Our ref: KT/2023/130482/01-L01
Your ref: TR020005
Date: 26 June 2024

**Gatwick Airport Northern Runway Development Consent Order Application –
Deadline 6 - Environment Agency comments on further submissions by
Deadline 5**

Figure 14-3: Western Noise Bund Design.

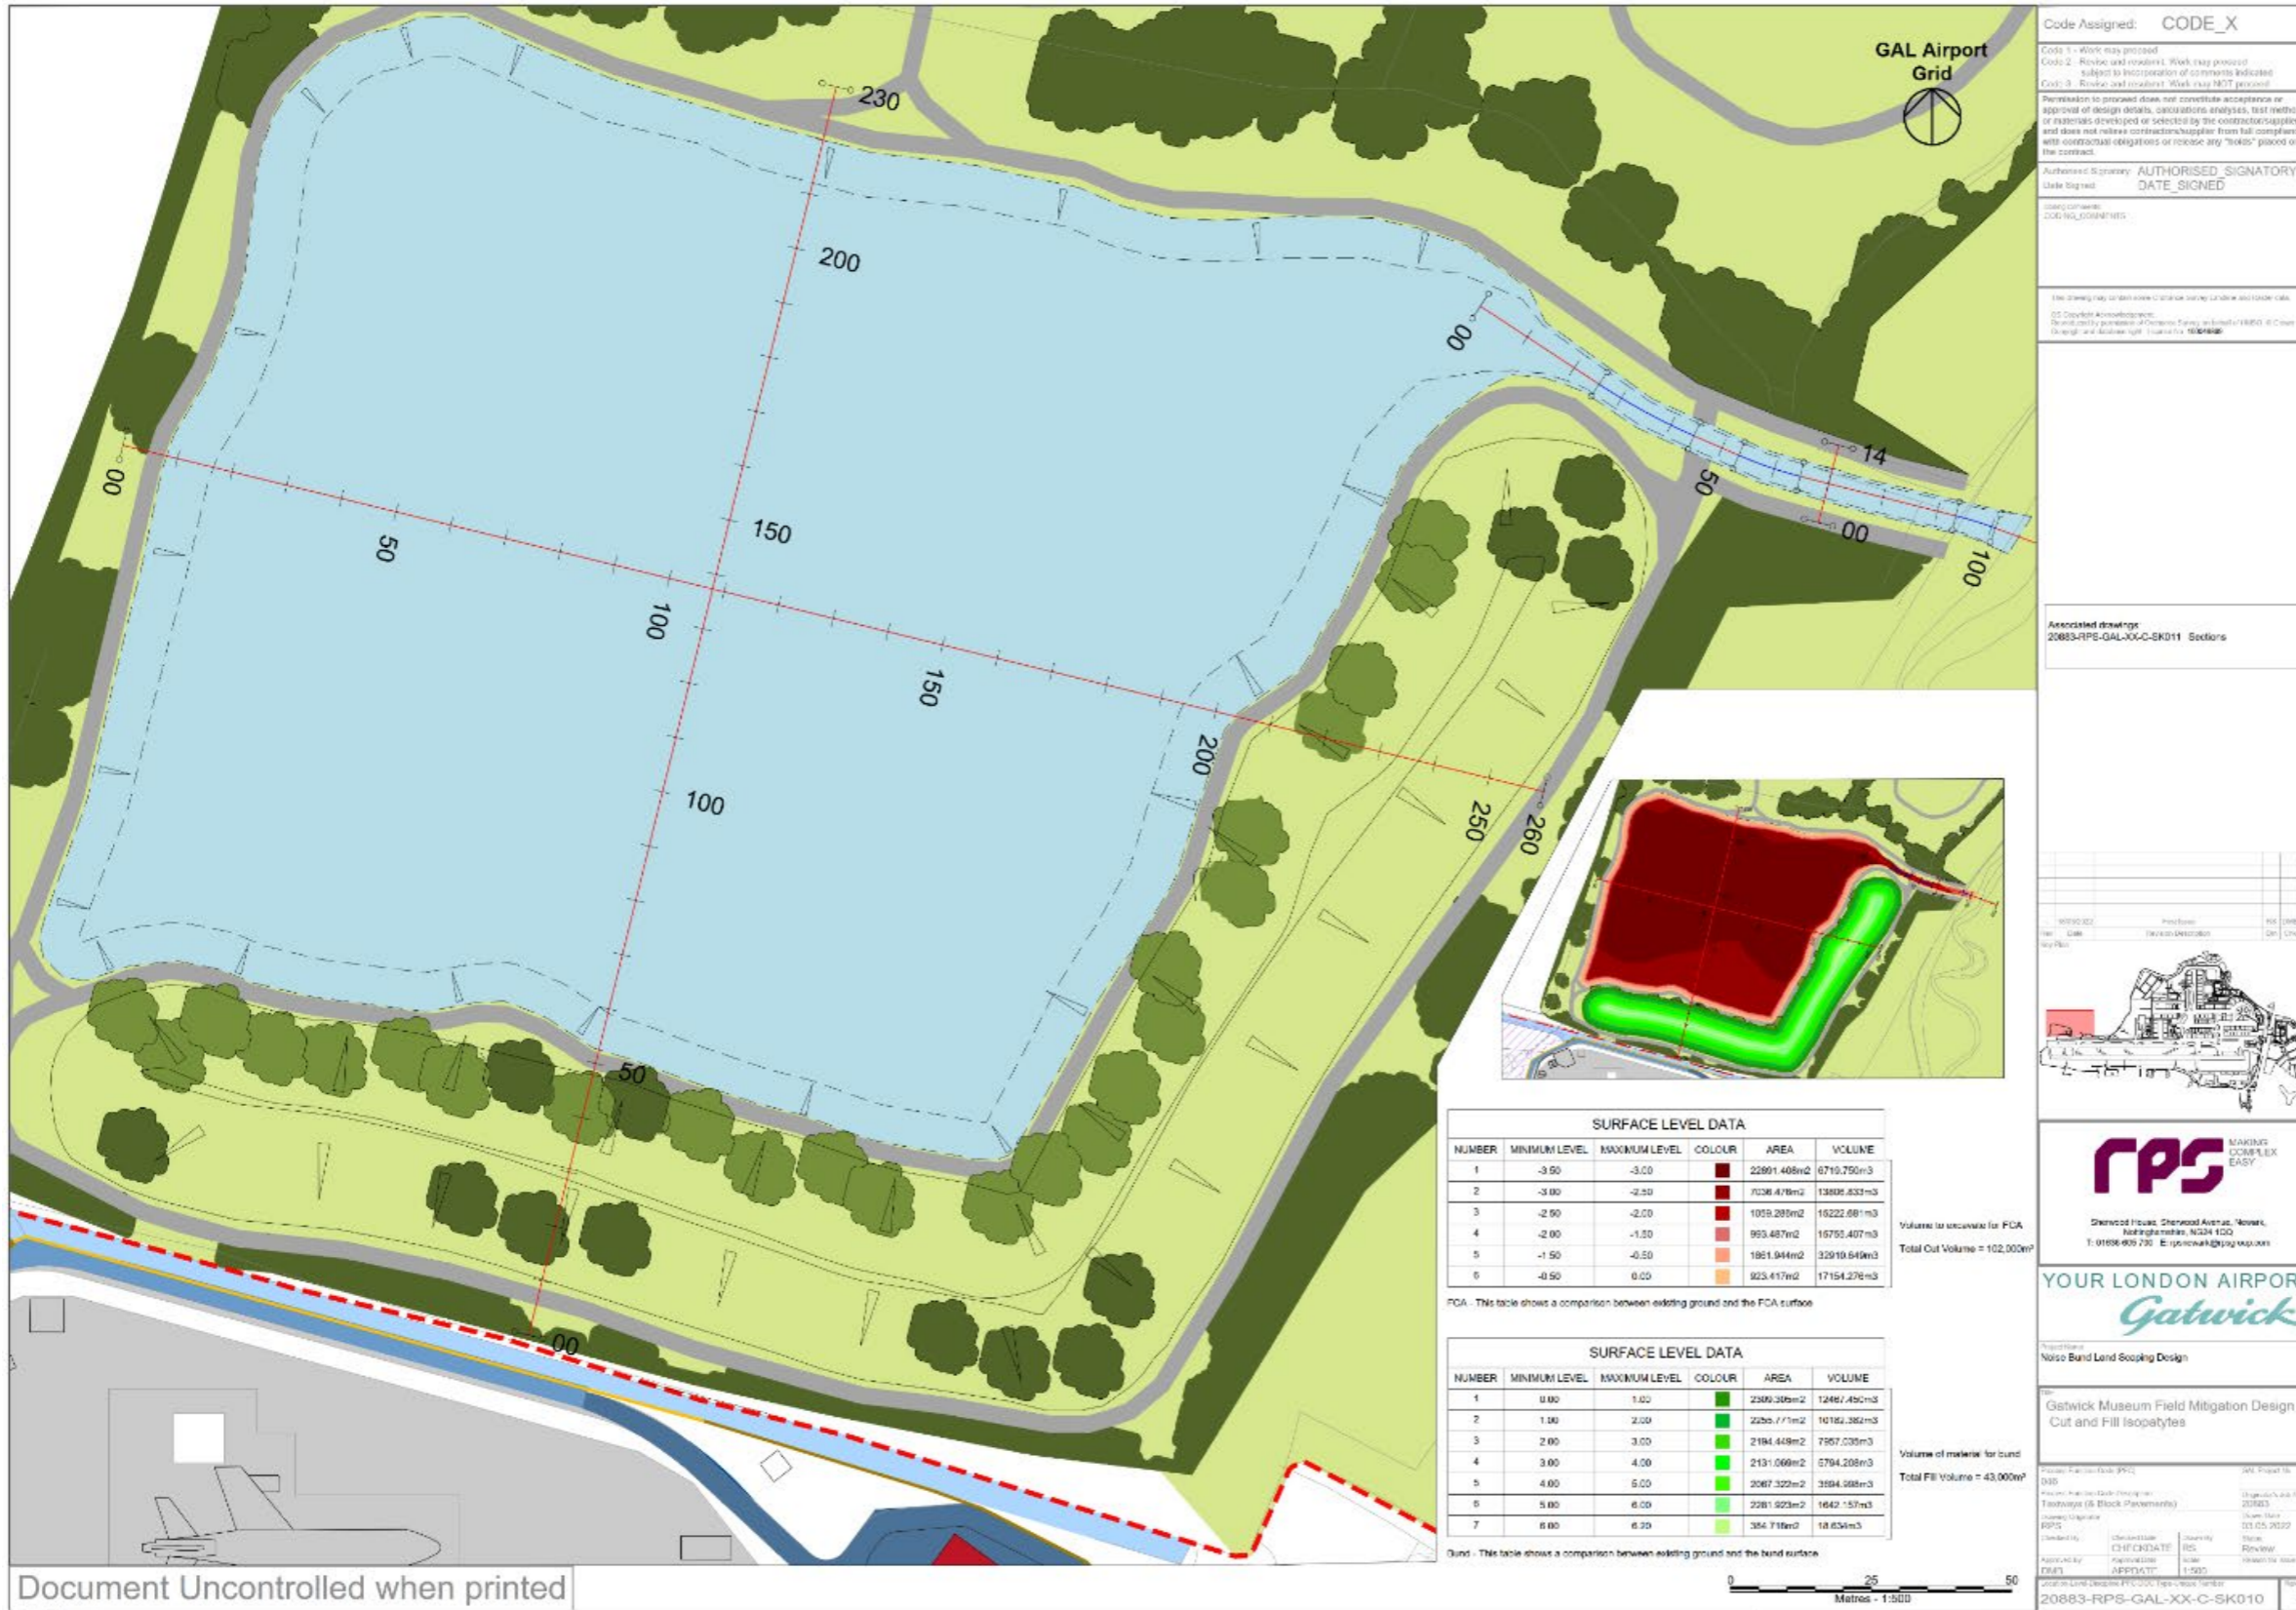
DDP13 – Reference is made to syphons beneath ‘the noise bund’ to maintain floodplain connectivity. It would be helpful for the applicant to clarify the location of this noise bund to ensure it is clear, does this related to the western noise bund for example? As highlighted in our comment above around the now deleted DBF260 related to the active travel path syphons, further details should be given to why these have been removed and if they are to be retained, or may be retained, they should be reference under this Design Principle.

In terms of the fluvial mitigation to be delivered prior to other works commencing, the flood conveyance syphons required for the taxiways, western noise bund and the active travel path are essential aspects. As already highlighted, these syphons are not listed under a Work Number in Schedule 1 and we would question whether the flood conveyance syphons should also be listed under Requirement 23 in order to secure their delivery alongside the other fluvial mitigation elements.
